Application No: R/25/22/HH
Site Address: 82 North Lane Rustington BN16 3PW
Description of works: Proposed 2nd floor and installation of a car port to front.

Thank you for your internet representation made on 25th March 2022 which has been recorded as an objection with the comments as follows:

PROPOSED GROUND FLOOR PLAN

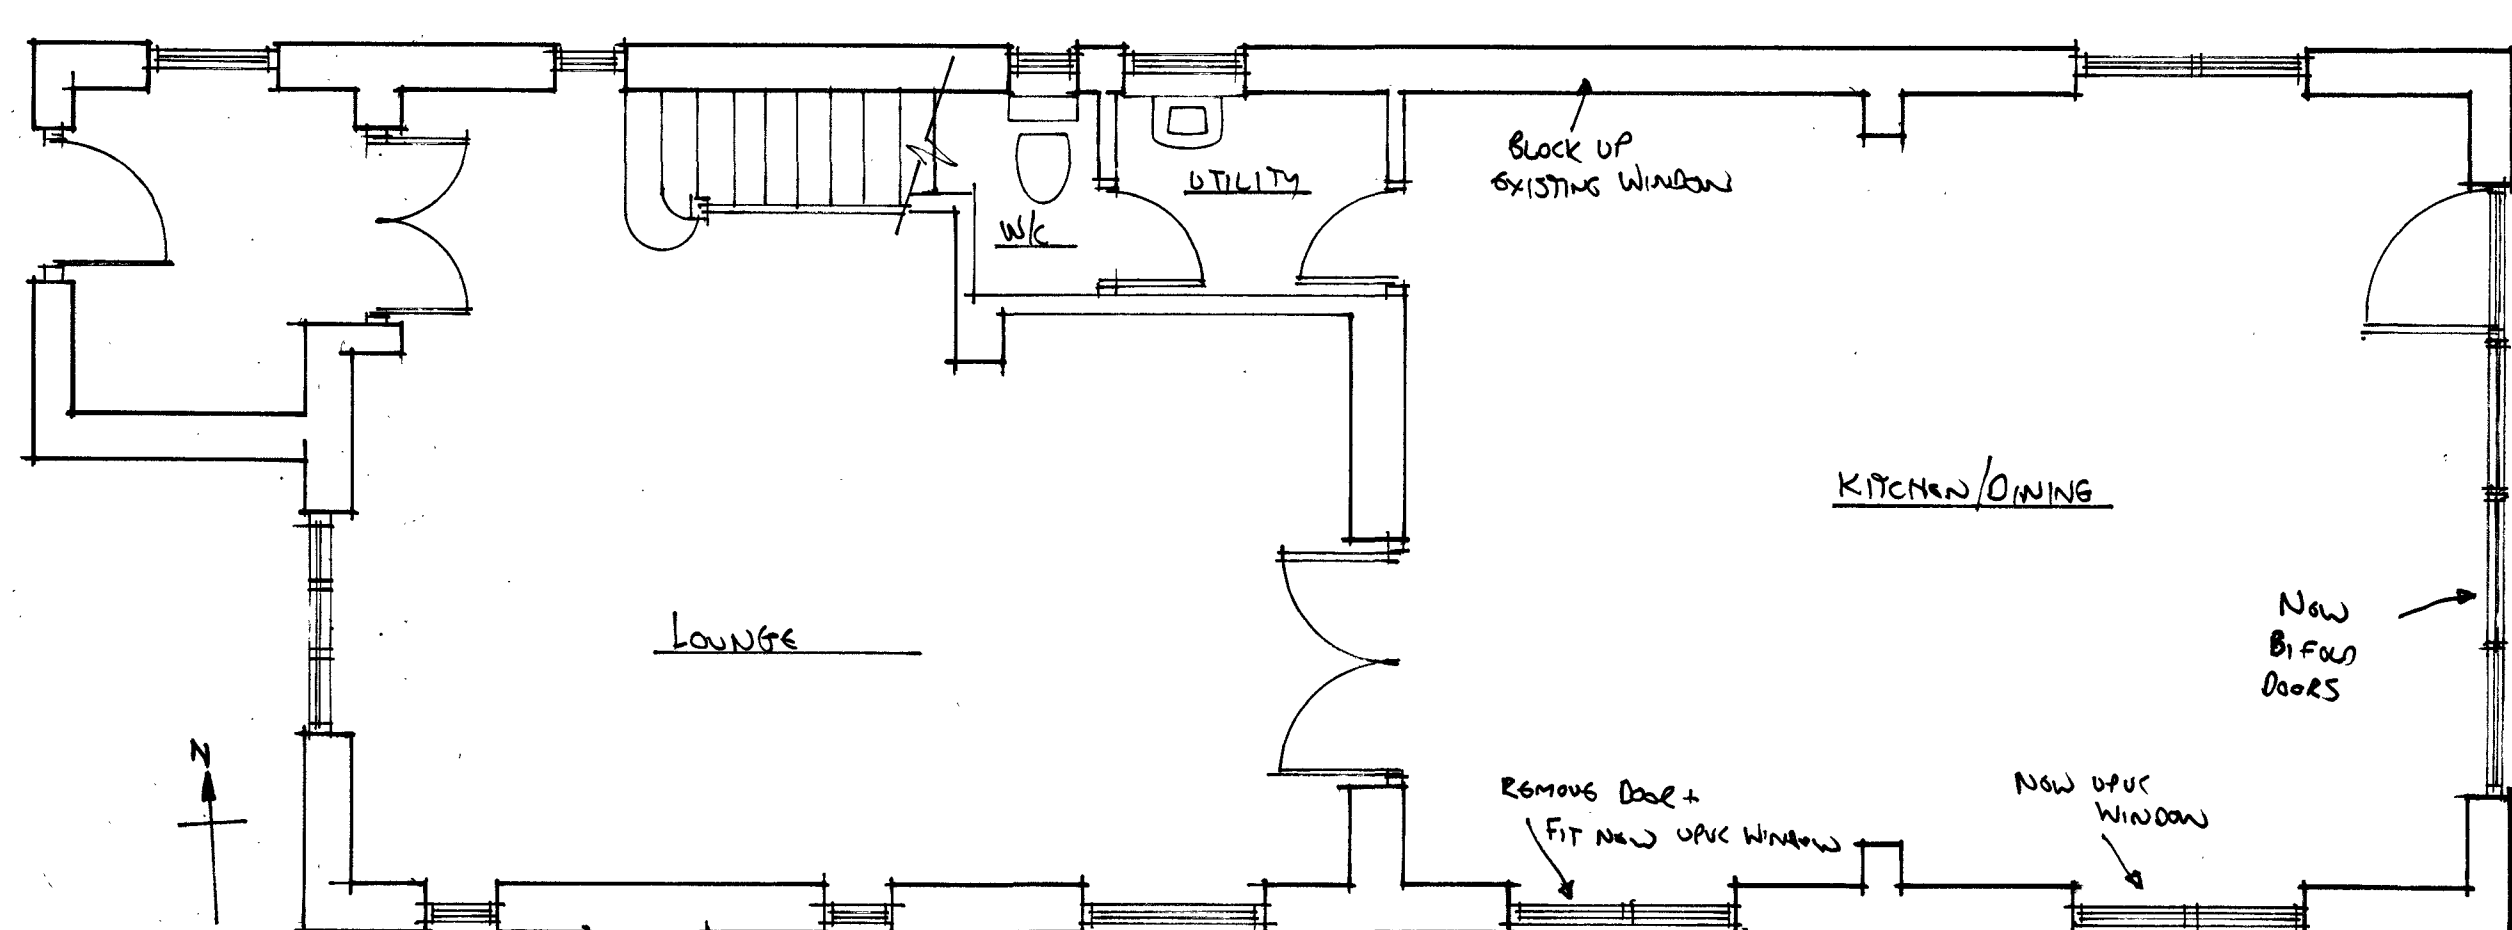
I live at the neighbouring property and haven't got a issue with the rear extension. The only issue I have is the front car port positioning as it is on the boundary which would restrict our view for exiting the driveway. If it could please be considered the placement for the view of the road. Also the outlook from our property with a pitched roof will be restricted due to our ground level being lower.
